V2_Elevation Plans.pdf Markup Summary

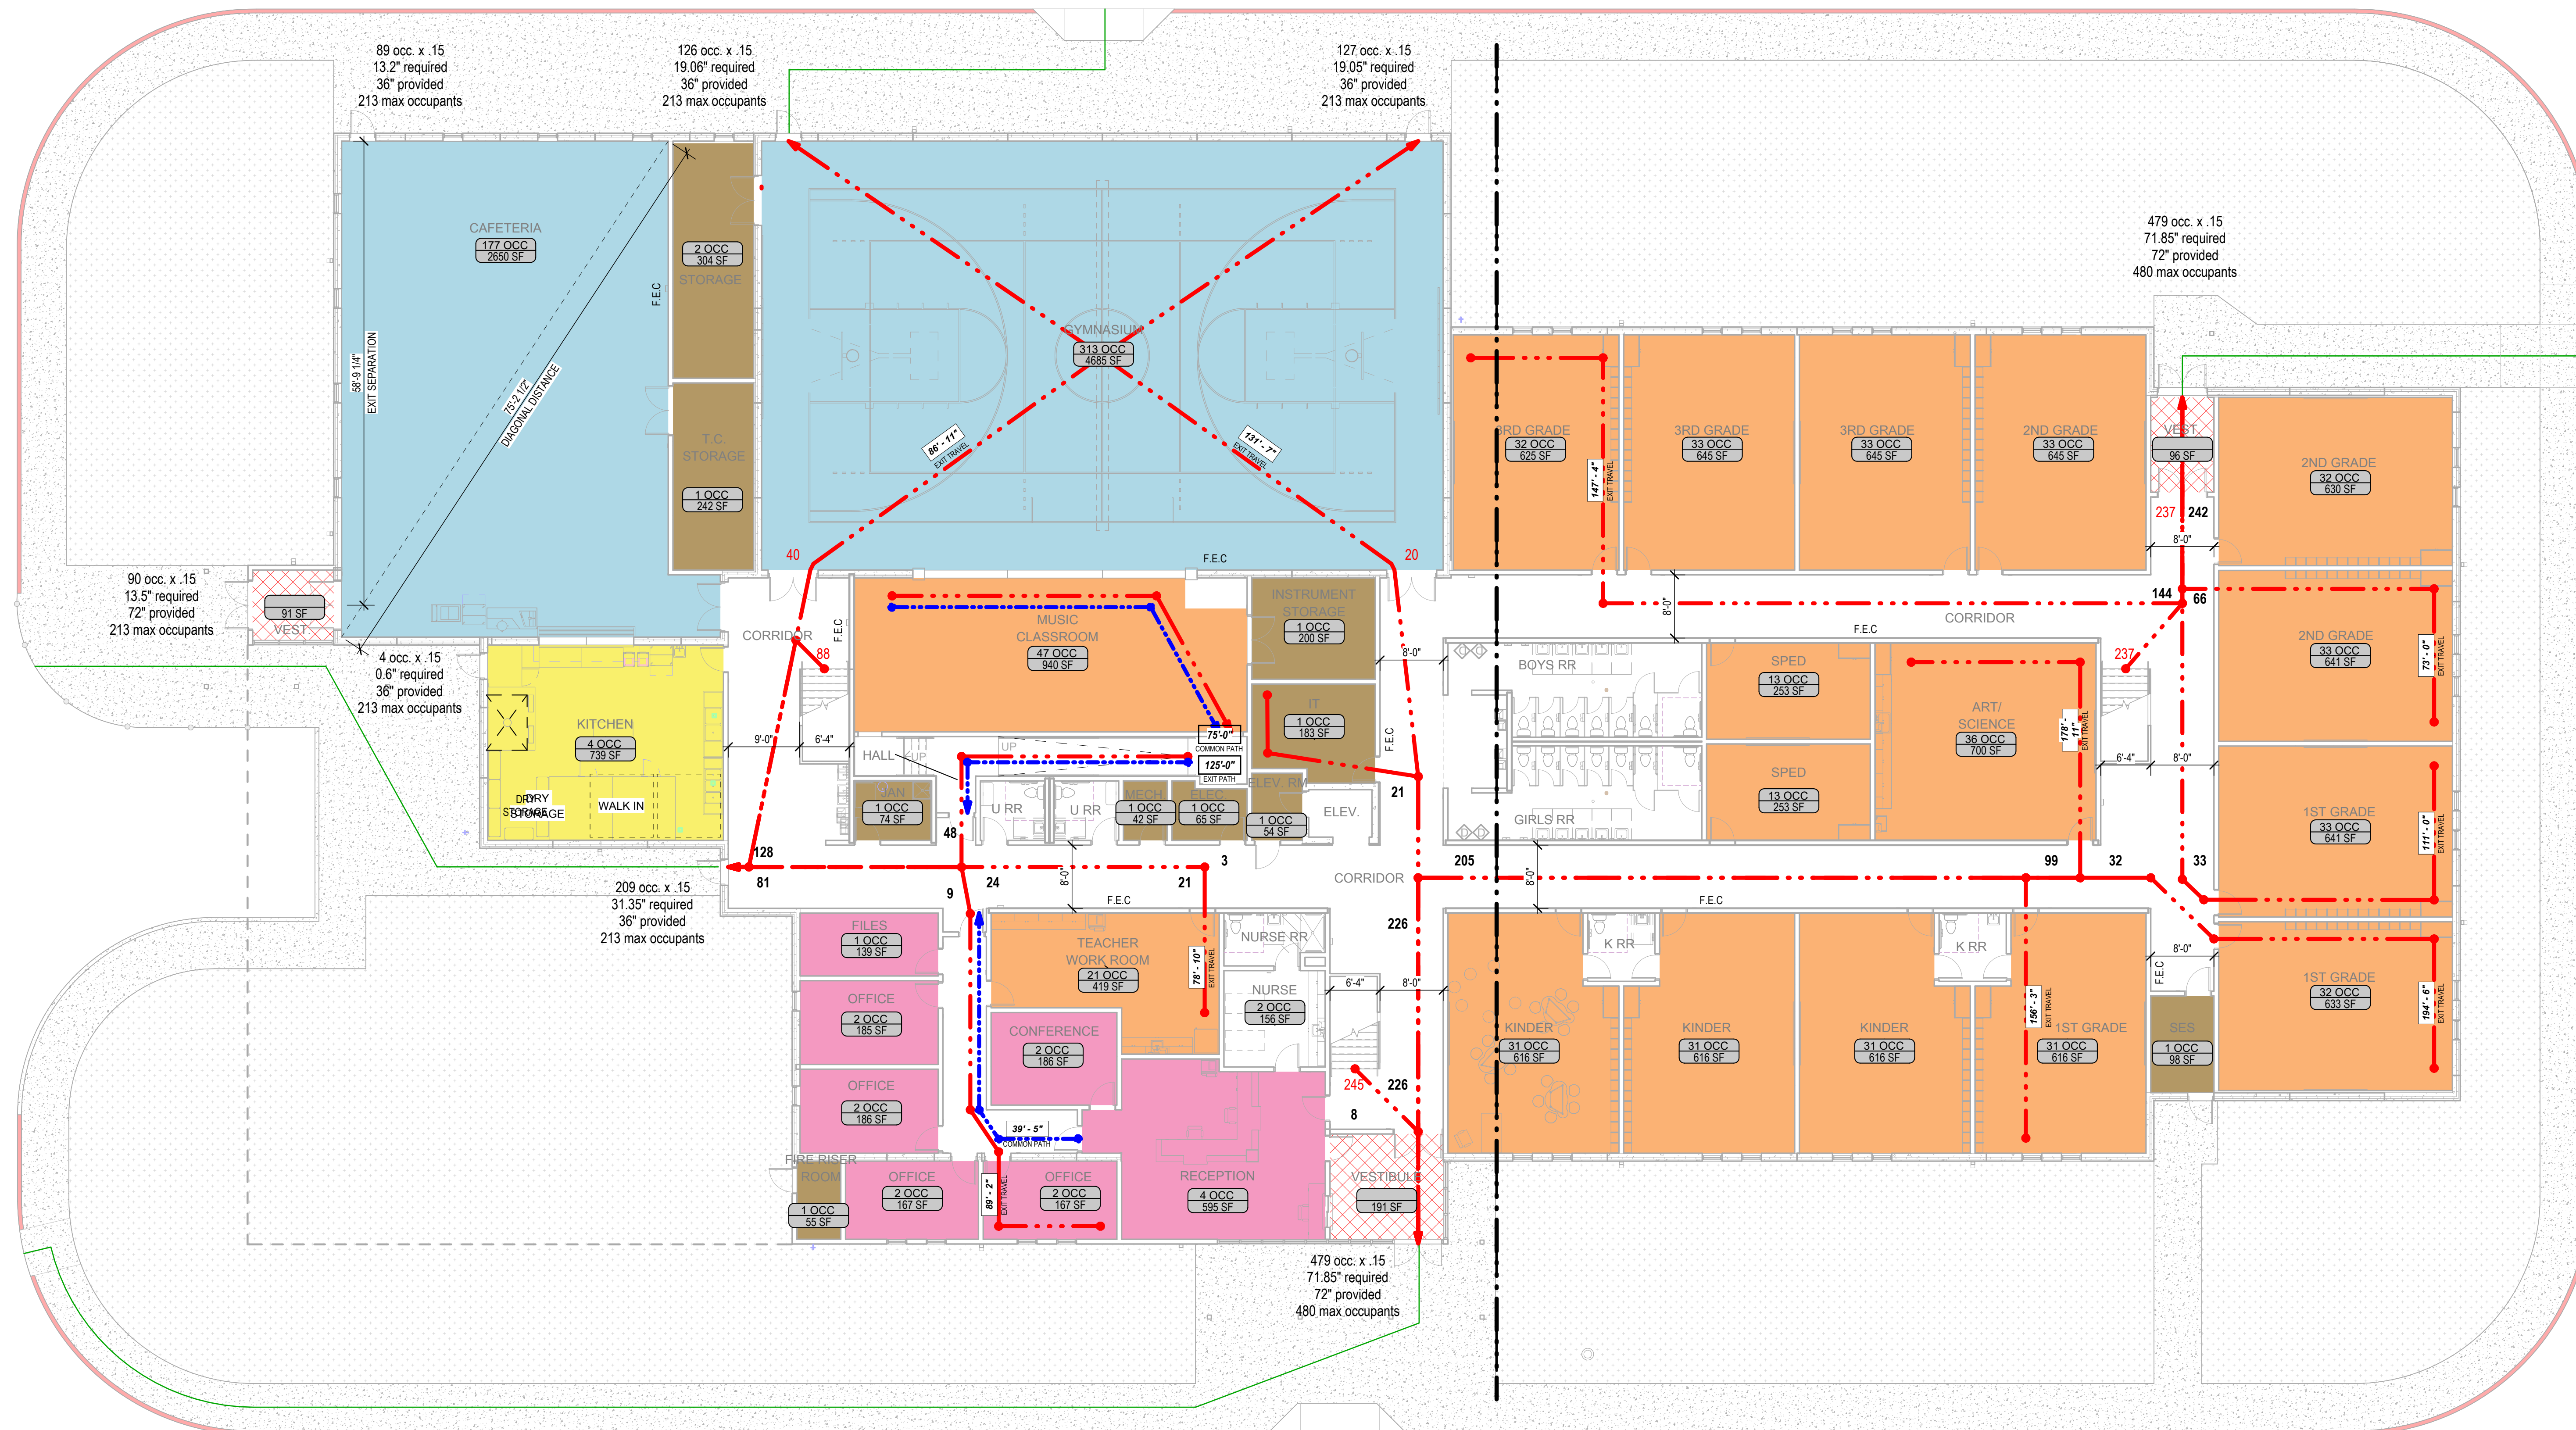
remove the red call outs and leave info so we can approve these after comments are addressed please
CLOUD CALL OUTS REMOVED

AS101

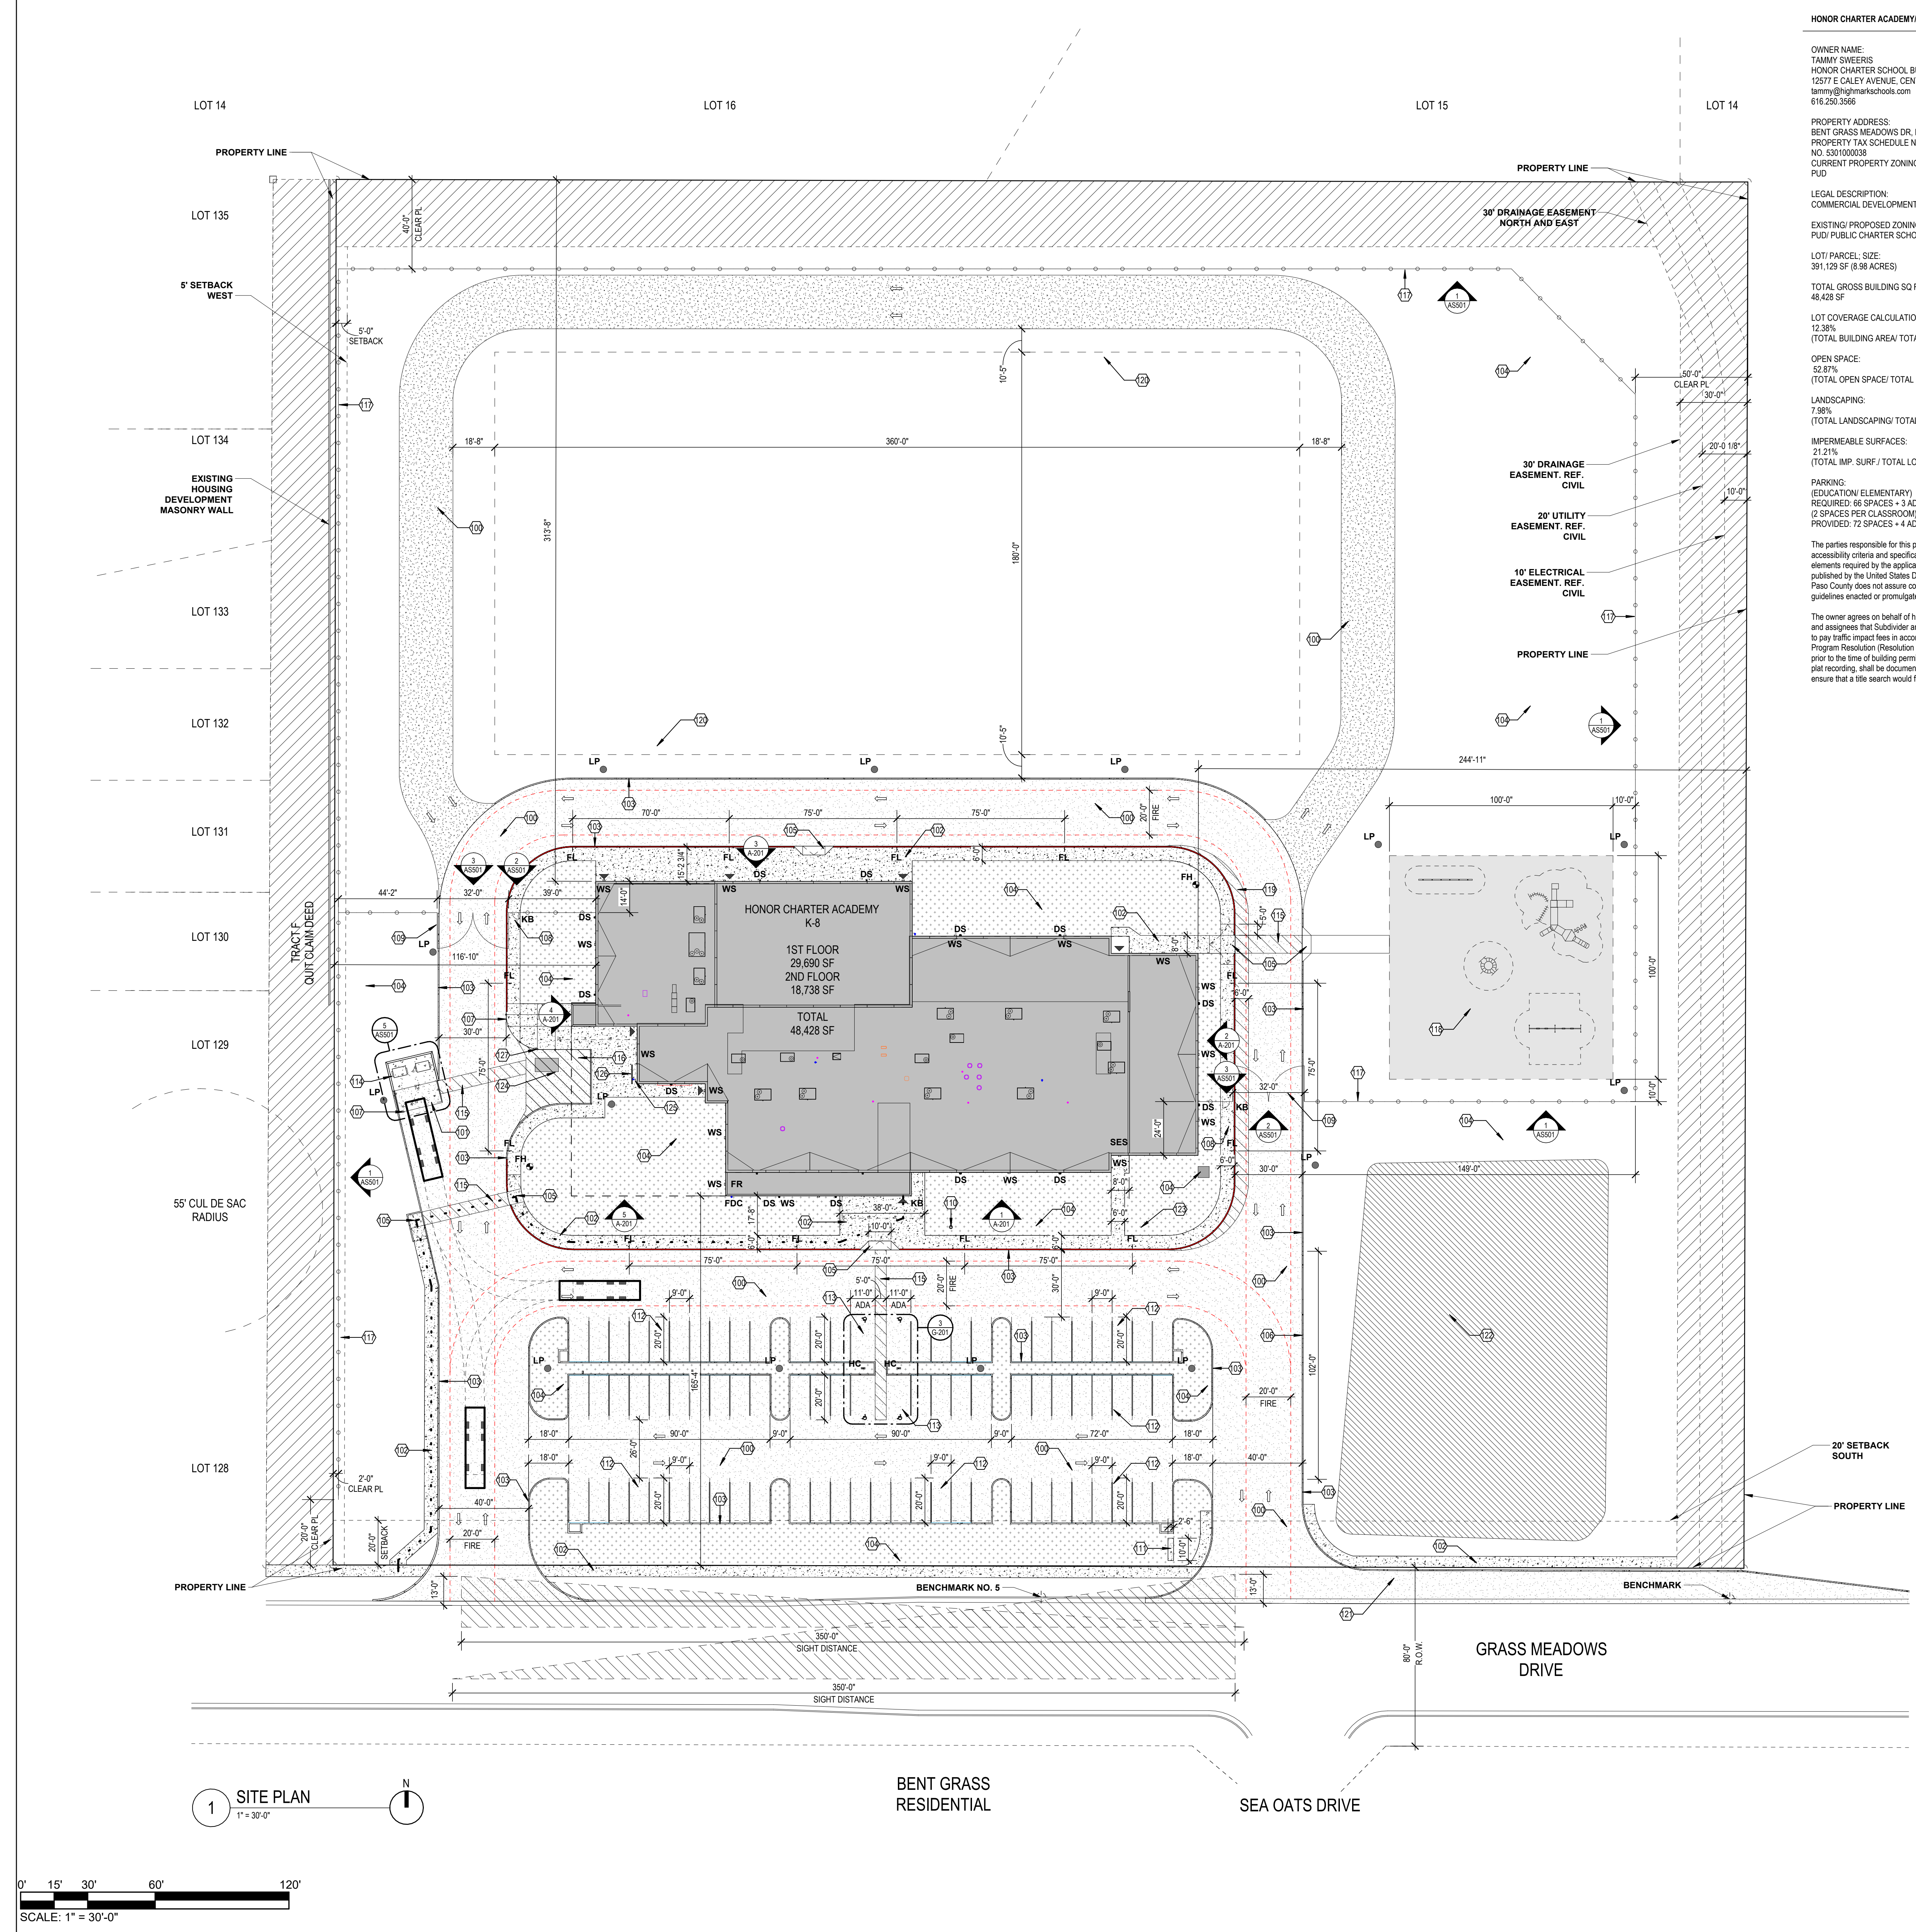
Buffers are required at northern and western prop lines

15'
SETBACK ADJUSTED TO 15'

Subject: Planner
Page Label: 1
Author: dsdparsons
Date: 7/13/2026 4:19:03 PM
Status: CHAIN LINK FENCING WILL BE PROVIDED AT THE EAST PROPERTY LINE (AS SHOWN ON SHEET AS101).
Color: ■ SOLID/ WOOD FENCE WILL BE ADDED AT THE NORTH PROPERTY LINE, AND THE WEST PROPERTY LINE (AS SHOWN ON SHEET AS101) BEGINNING WHERE THE EXISTING RESIDENTIAL WOOD FENCE ENDS/ AND CONTINUE
Layer: DOWN TO THE SOUTHWEST CORNER PROPERTY LINE). THUS, THE ENTIRE WEST PROPERTY LINE WILL HAVE A WOOD FENCE. PLEASE REFER TO SITE DETAILS SHEET AS501 FOR FENCING ELEVATIONS AND DETAILS.
Space:
